No.	Comment	Response
<b>Key Recommendations</b>		
1	The Panel appreciates the refinements to the proposal since it last attended the UDRP in 2019.	Noted and appreciated
2	The Panel recommends further refining the integration of the development with the public realm, with particular regard to the interactions at the ground level along St-Joseph Boulevard and the 1st level along Duford Drive.	The ground level has been redesigned to provide more generous tree planting areas with increased soil volumes, which will assist in greening the public realm. The proposed development includes 2 commercial units, which will contribute to animating the public realm, as will the open space and commercial patio at the corner of St. Joseph Boulevard and Duford Drive.

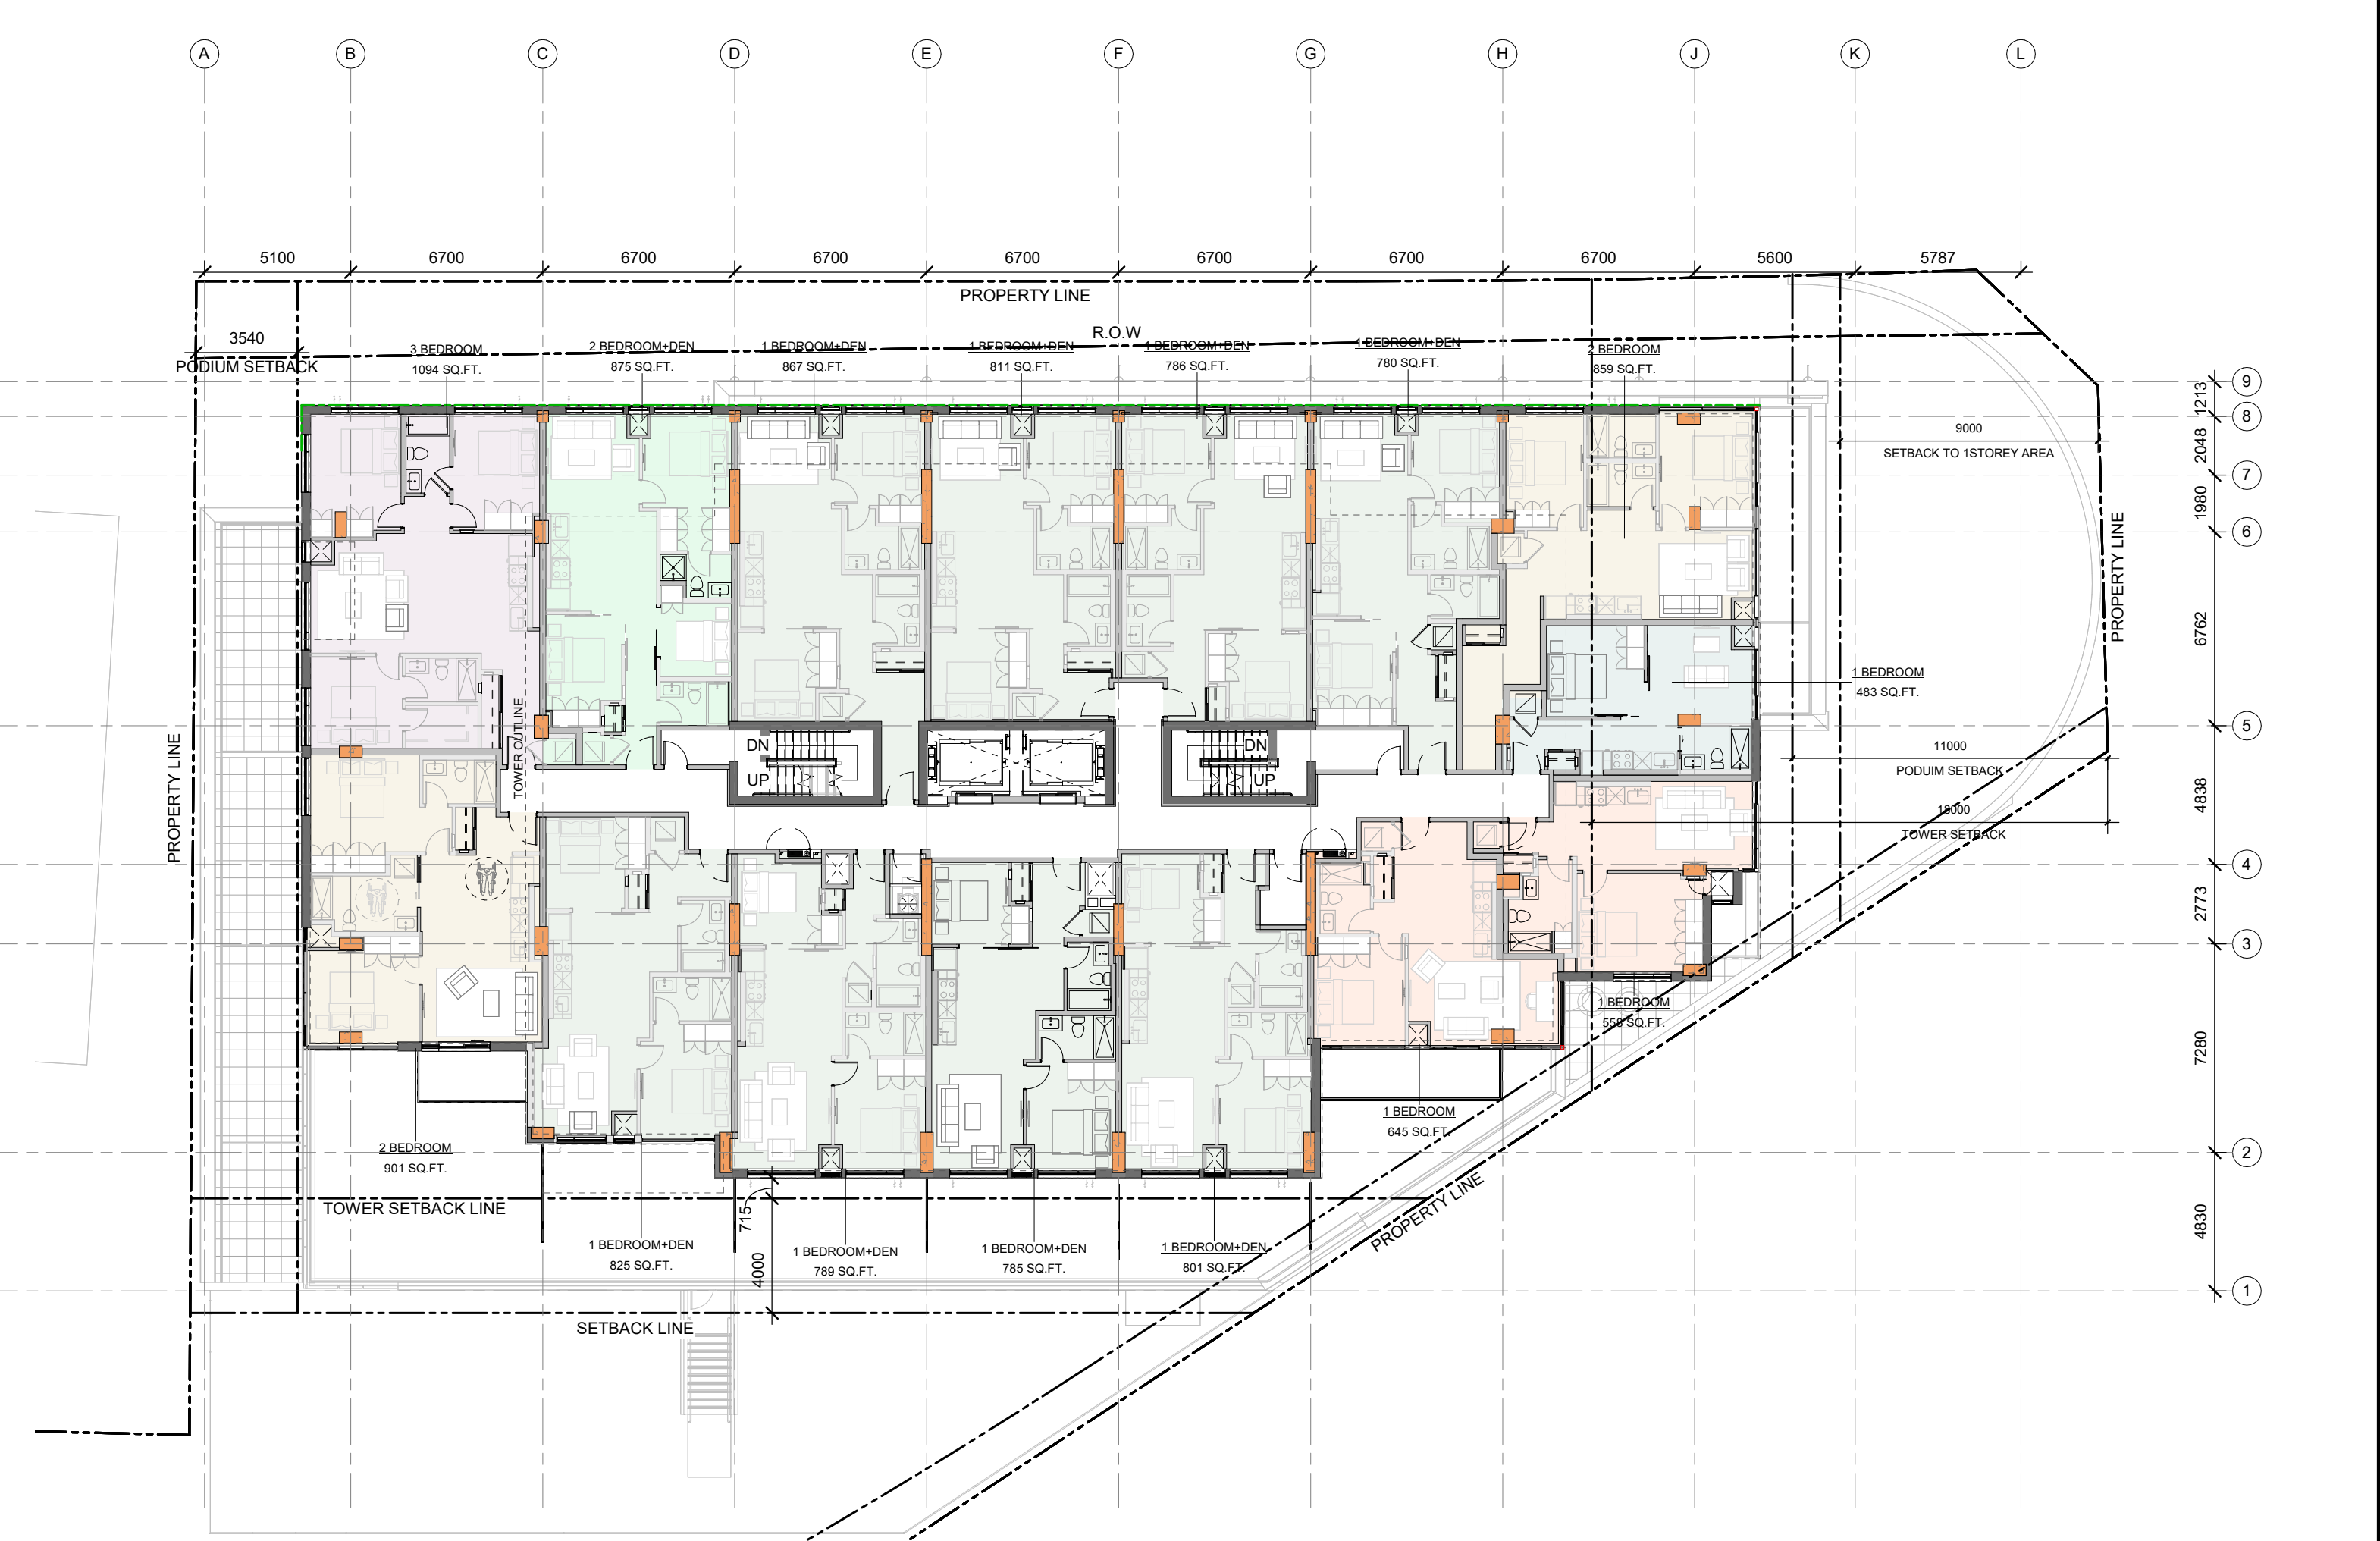
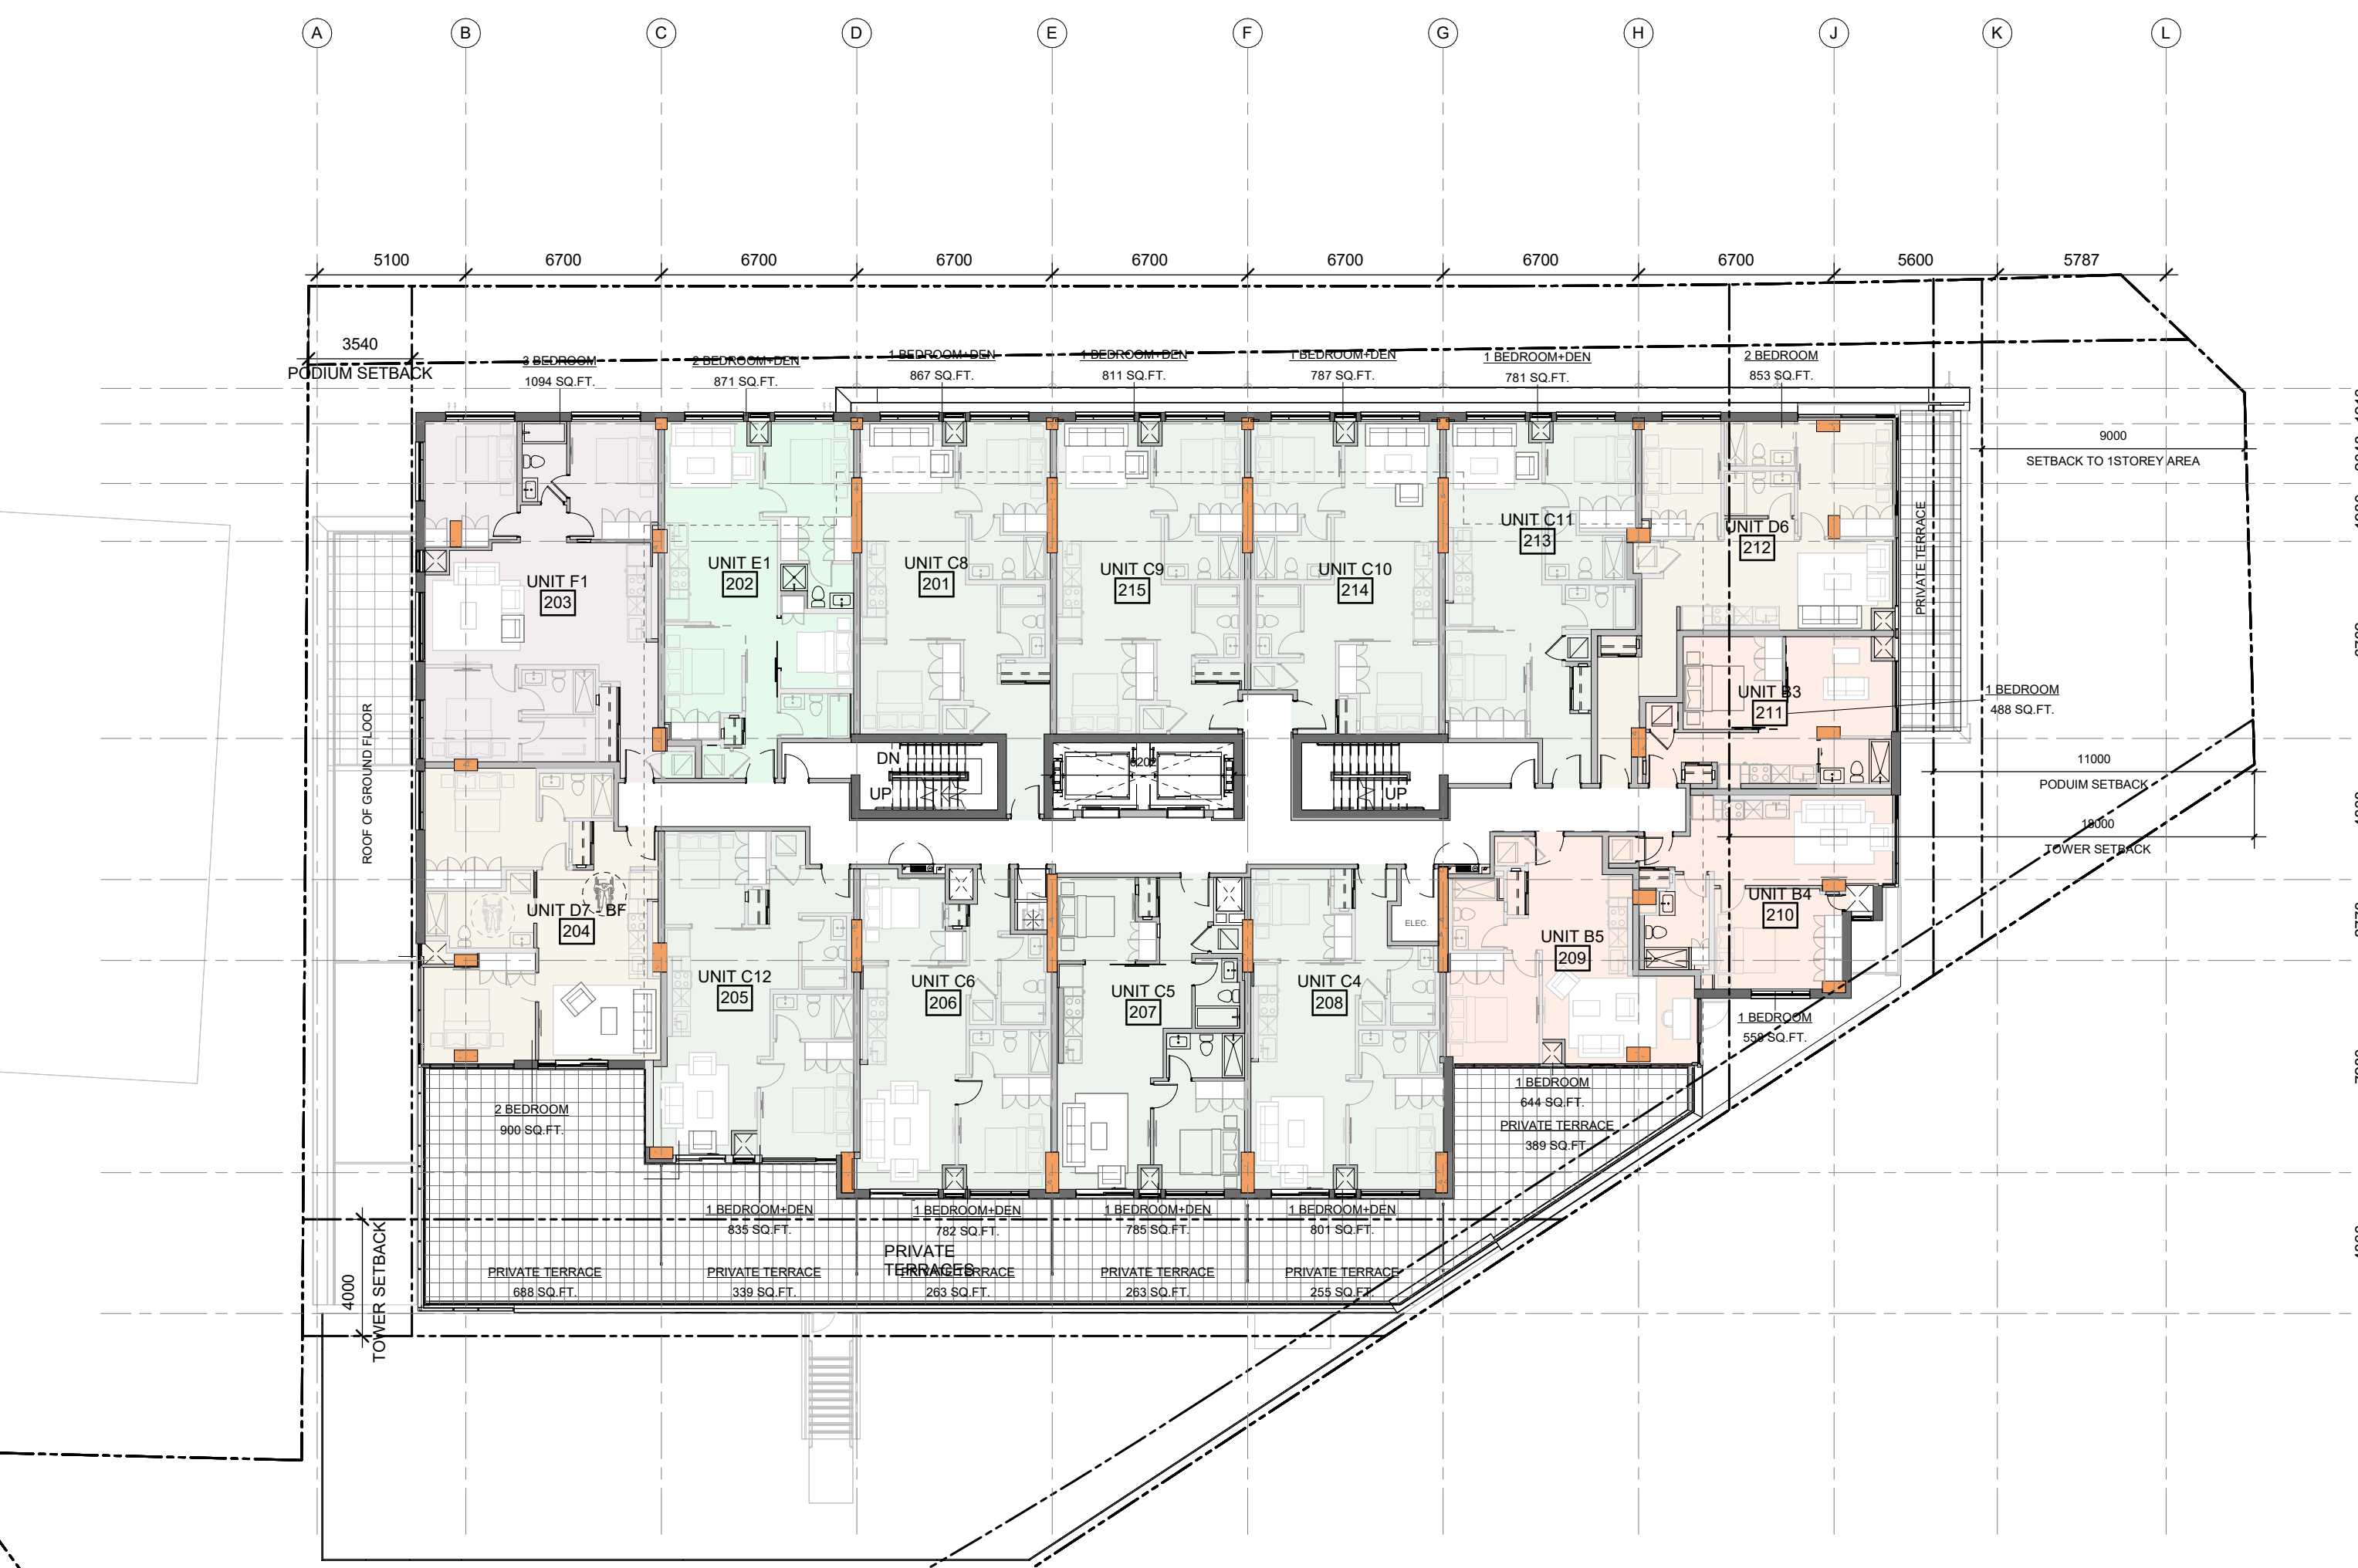
<b>Built Form &amp; Architecture</b>		
16	The Panel recommends refining the eastern elevation of the podium, as it is a particularly important view.	Noted, elevation articulation has been simplified per the updated elevations.

16.2	Consider the importance of that eastern corner view along the streetscape and as a gateway to the neighbourhood up the hill.	Noted.
17	The Panel has concerns with the window-wall element and how it wraps around the corners, both at the north-east corner and the south-west corner of the podium.	Noted, addressed in the updated elevations.

17.1	Consider using the podium brick material in place of the spandrels at both corner locations.	Noted.
17.2	Consider bringing the canopy and stone colonnade from the north façade around the eastern portion of the podium at the corner.	Noted, see response to comment to #3.3 above.
18	The Panel recommends pursuing a more contextual material for the podium than the black brick.	Noted, alternative colours were reviewed however not approved by Client.

18.1	Consider red brick, or a warmer tone than black brick, at this site.	See response to the comment above.
19	The Panel has concerns with the stark blank walls surrounding the garage entrance area.	Garage entrance area is now recessed and as such the blank wall massing has been significantly reduced.
